GROSVENOR PLACE NORTH PLAZA

ACCESS REVIEW

10 July 2015

REPORT REVISIONS		
Date	Version	Drawing No / Revision
10.07.2015	Final	DA-4_100_Location Plan, DA-4_101 Site Link George St Level Plan-01, DA-4_102 Site Link Harrington St Level Plan-01, DA-4_103_George Street Level Plan, DA-4_104_Harrington Street Level Plan, DA-4_105_North Plaza Plan, DA-4_106_North Upper Plaza Plan, DA-4_107_Harrington Street Glass Awning and DA-4_108_Elevations & Wayfinding Totem.

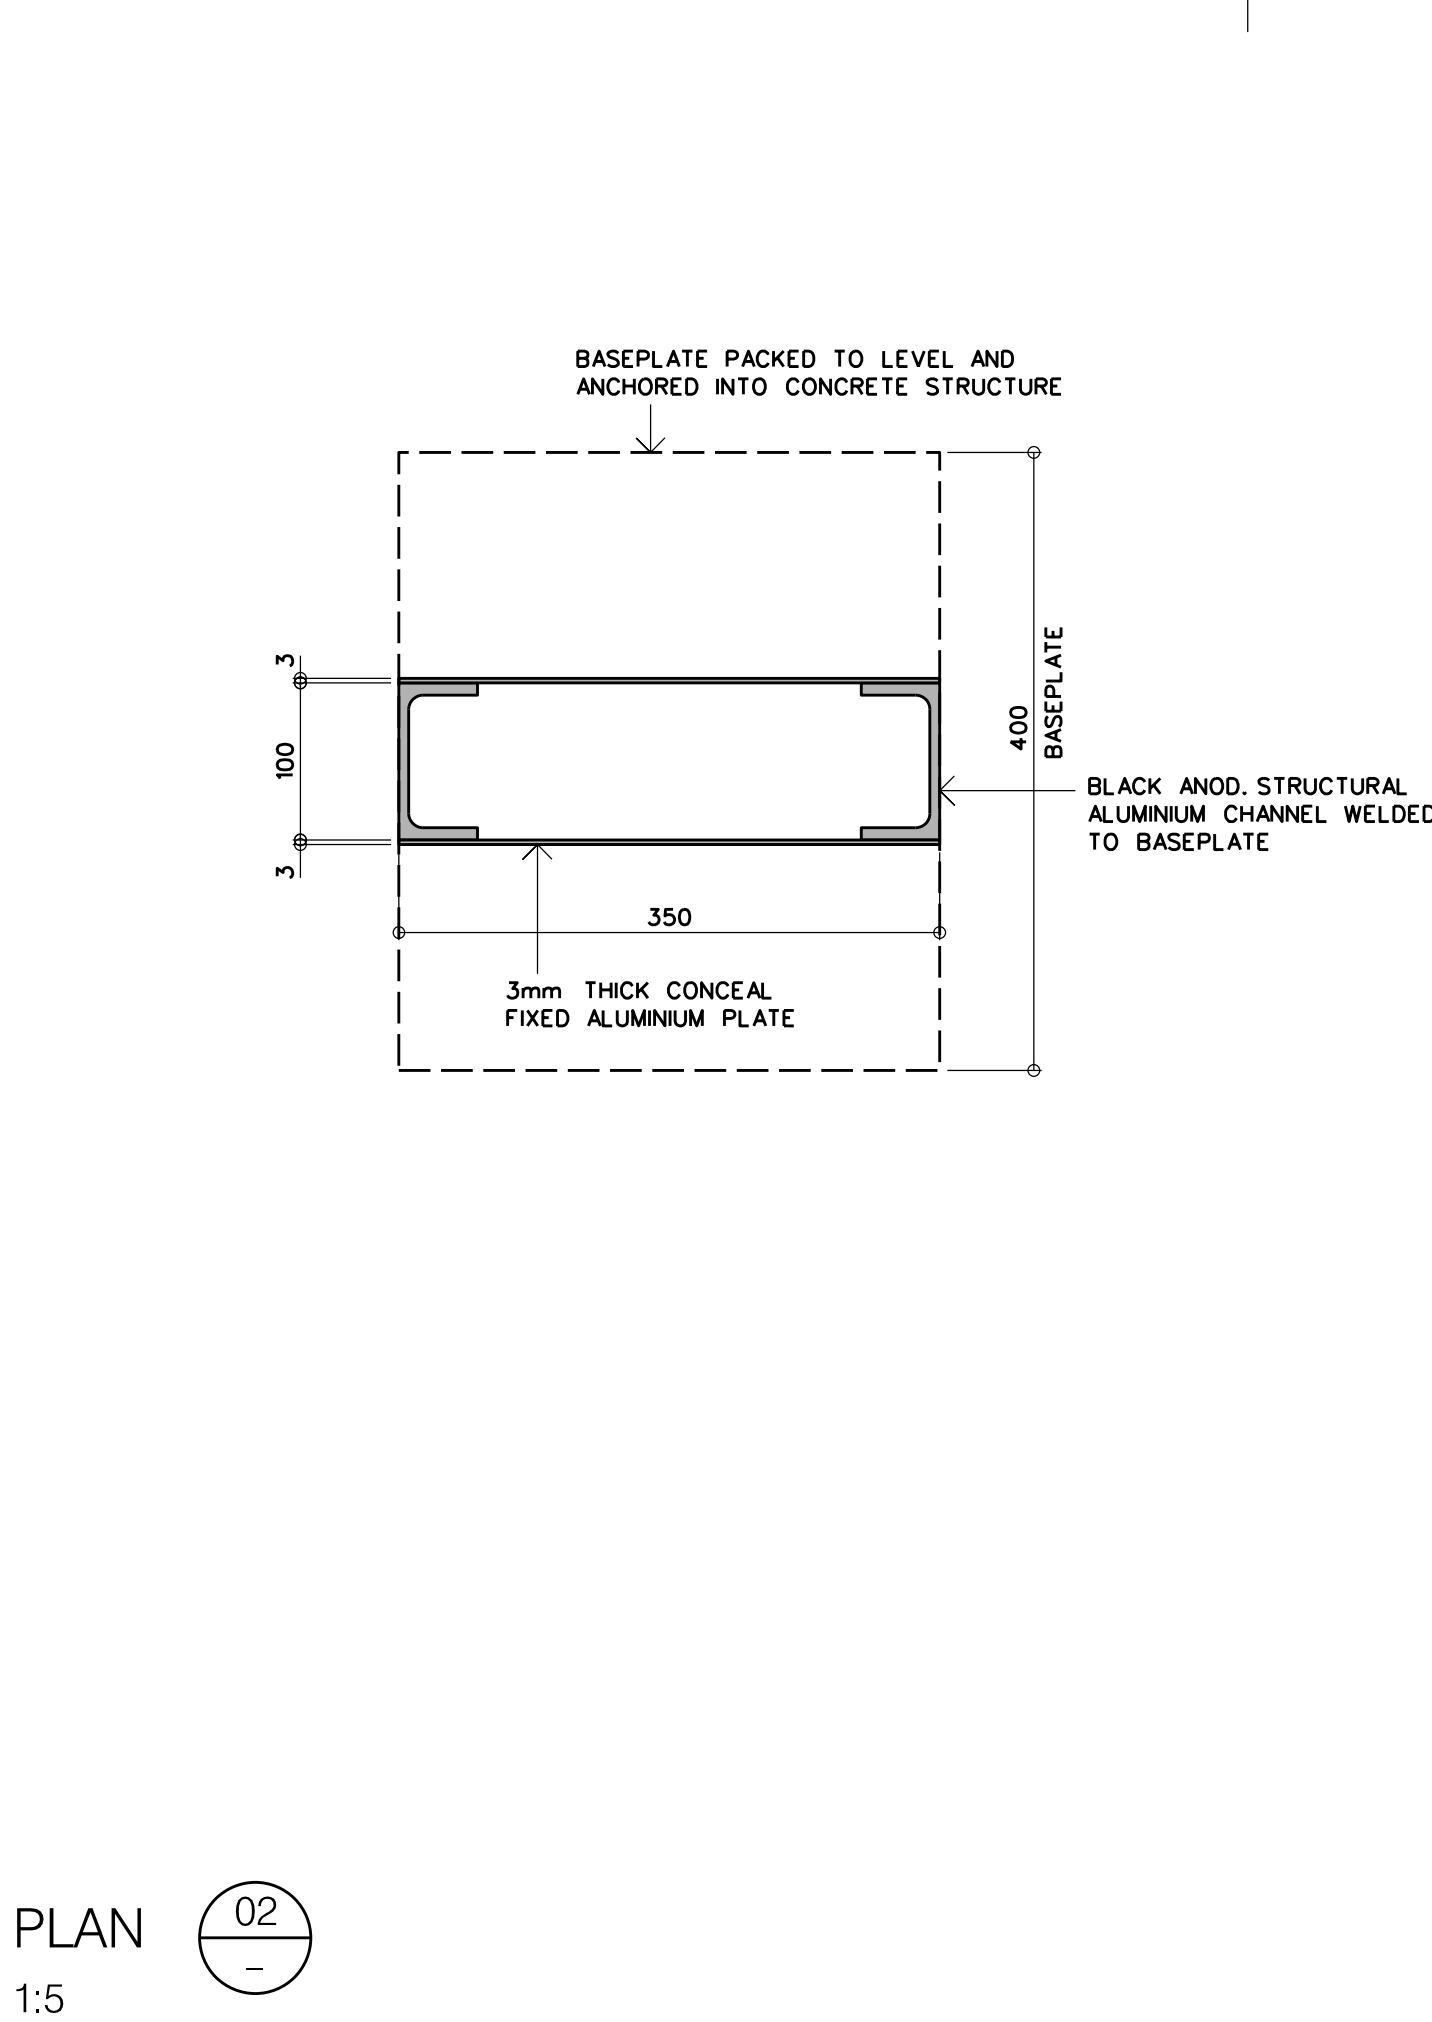
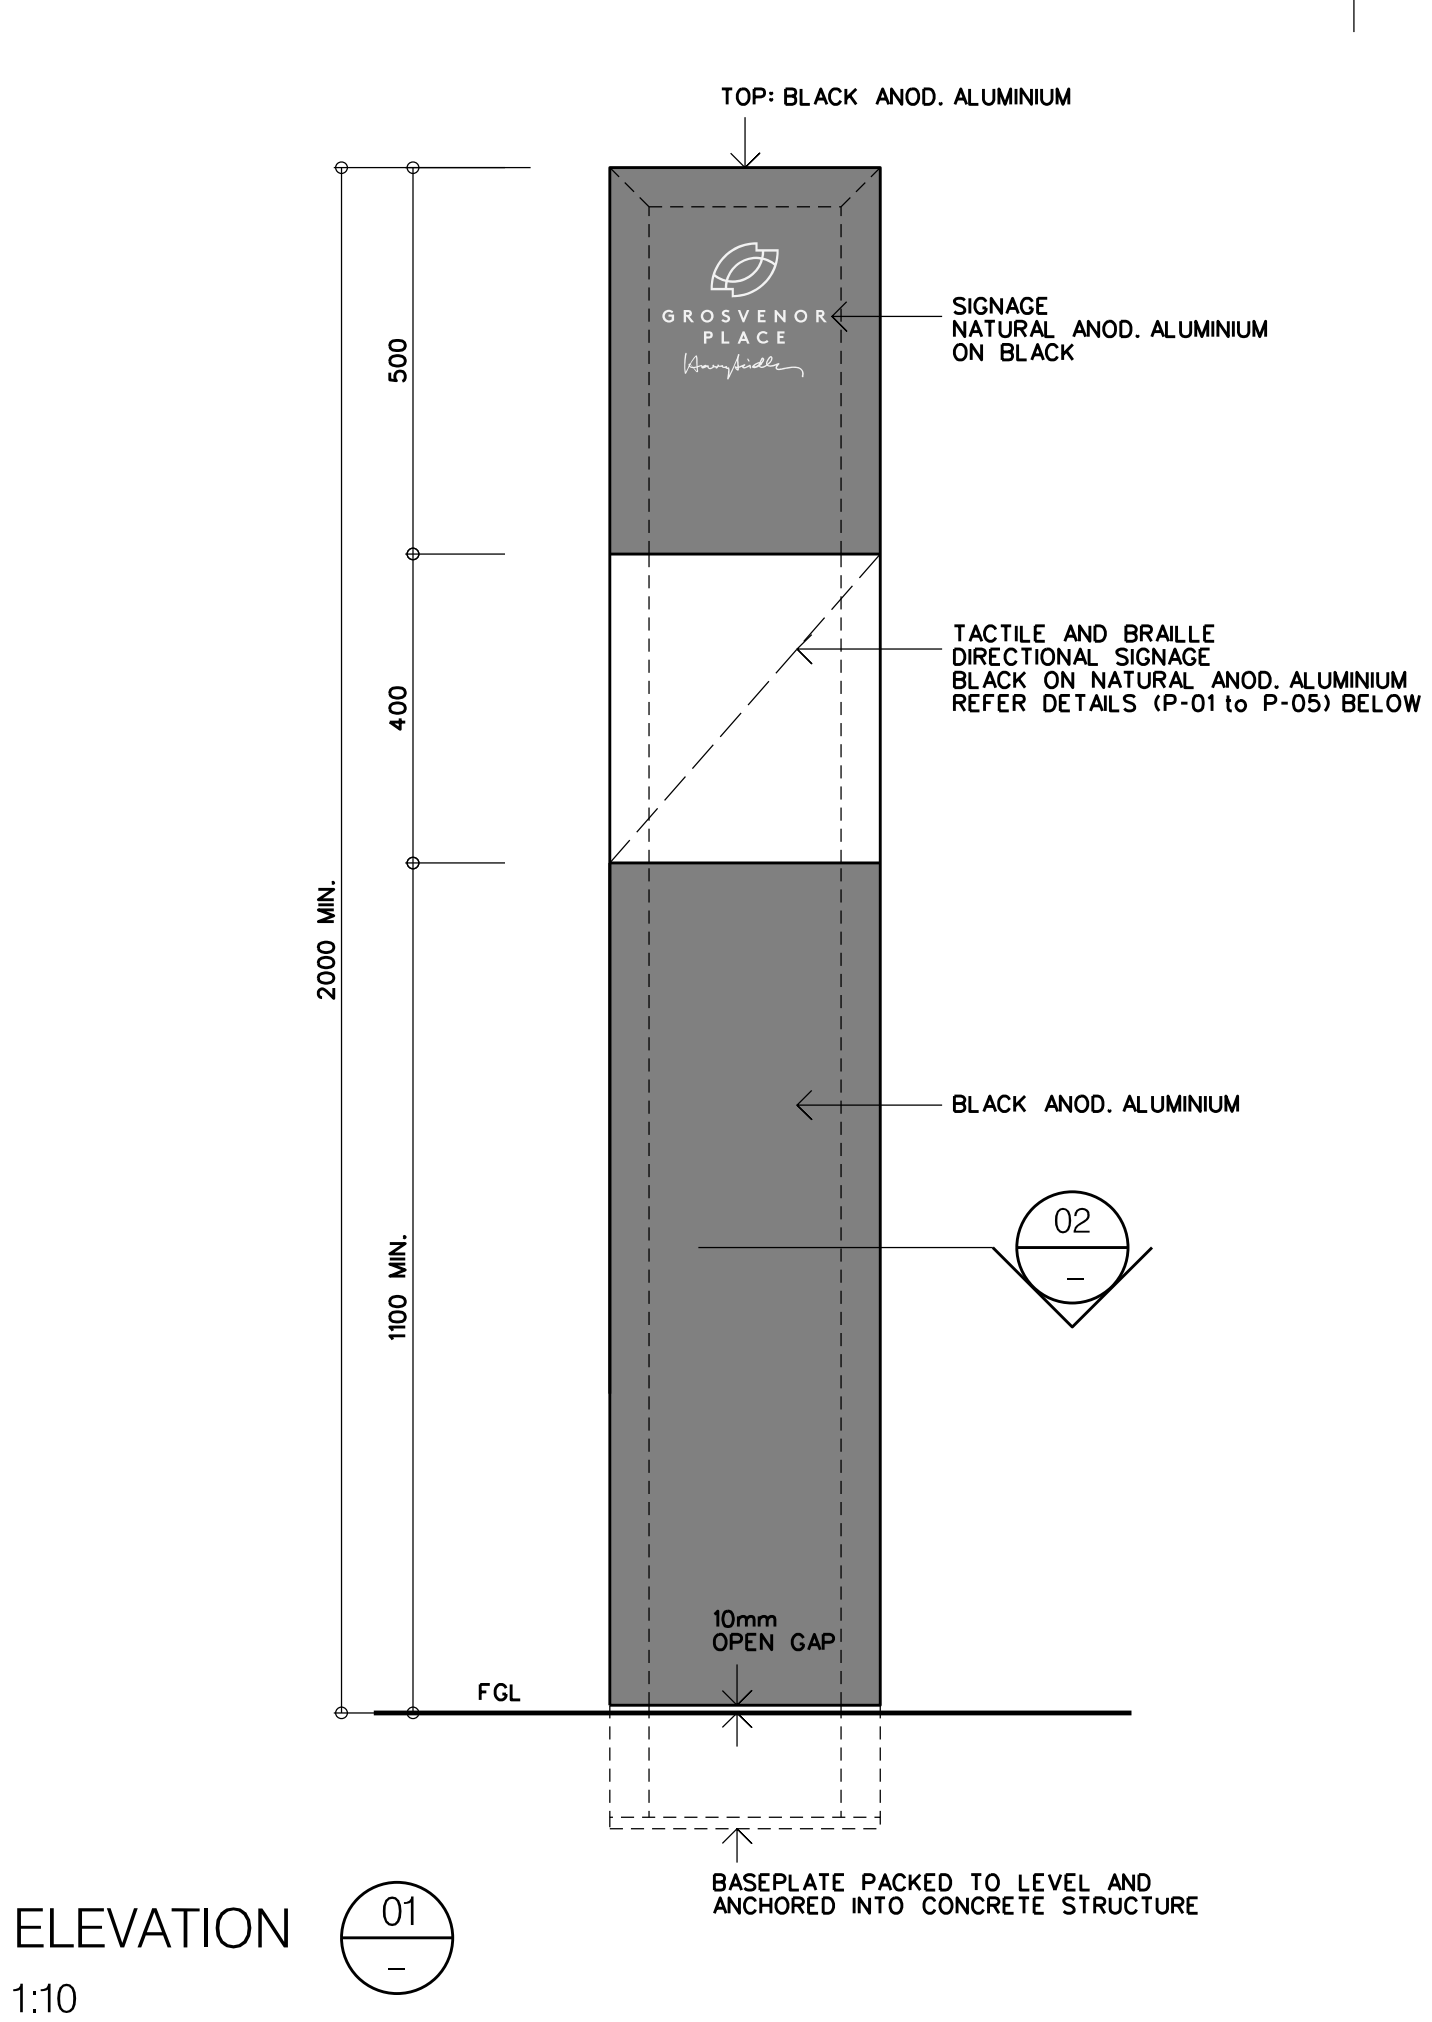
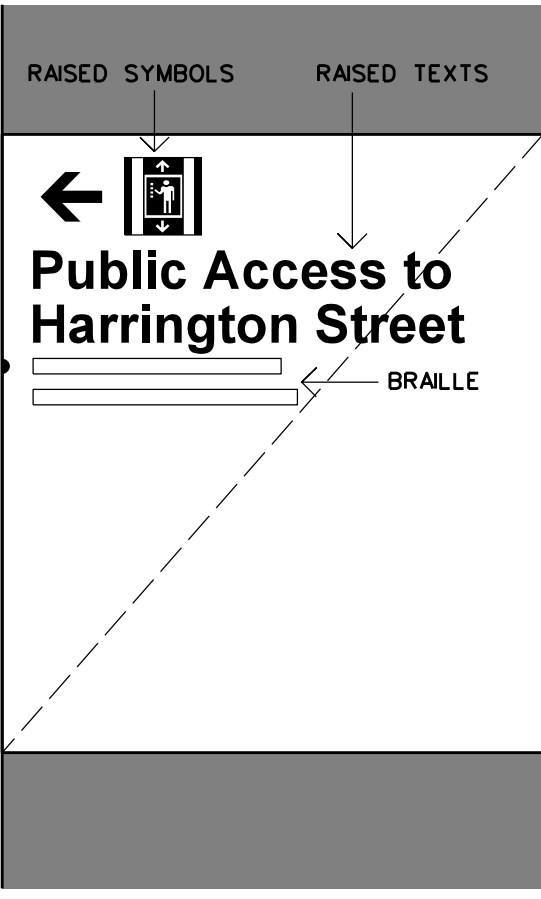
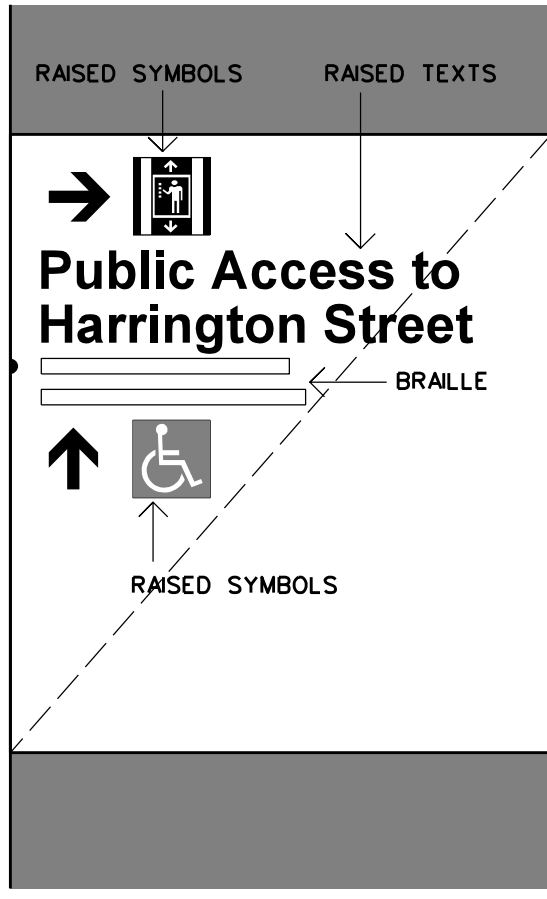
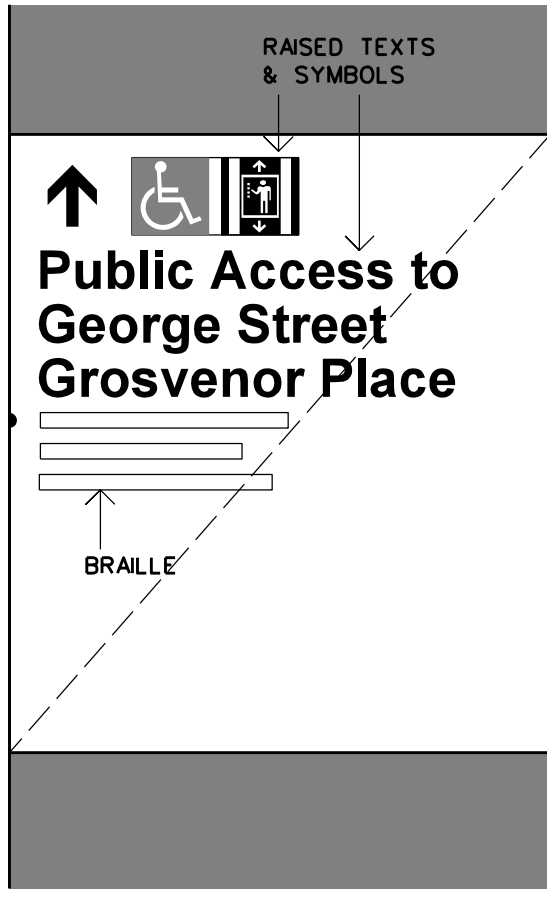
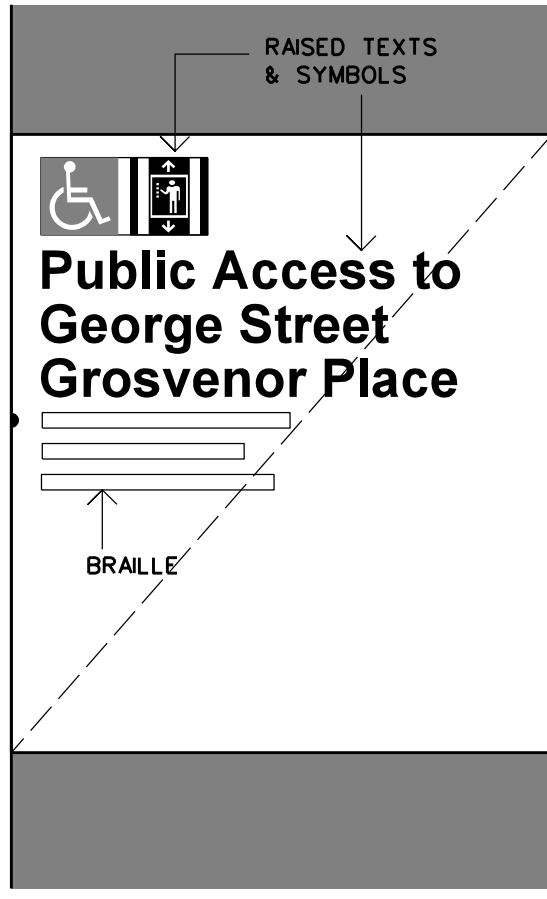
From the information provided there is new illuminated wayfinding totems installed. The main wheelchair access point (circular lift Harrington Street) has an international symbol of access (wheelchair logo) and text sign placed in an obvious location directing people to the circular passenger lift.

- Near the Harrington St passenger lift;
- Within plaza at the base of the Harrington Street stair;
- George Street stair near tenancy 3;
- Southern side fire stair (near Grosvenor Street);

- (i) Provide suitable way finding signage to comply with DDA Premises Standards and AS1428.1:2009.
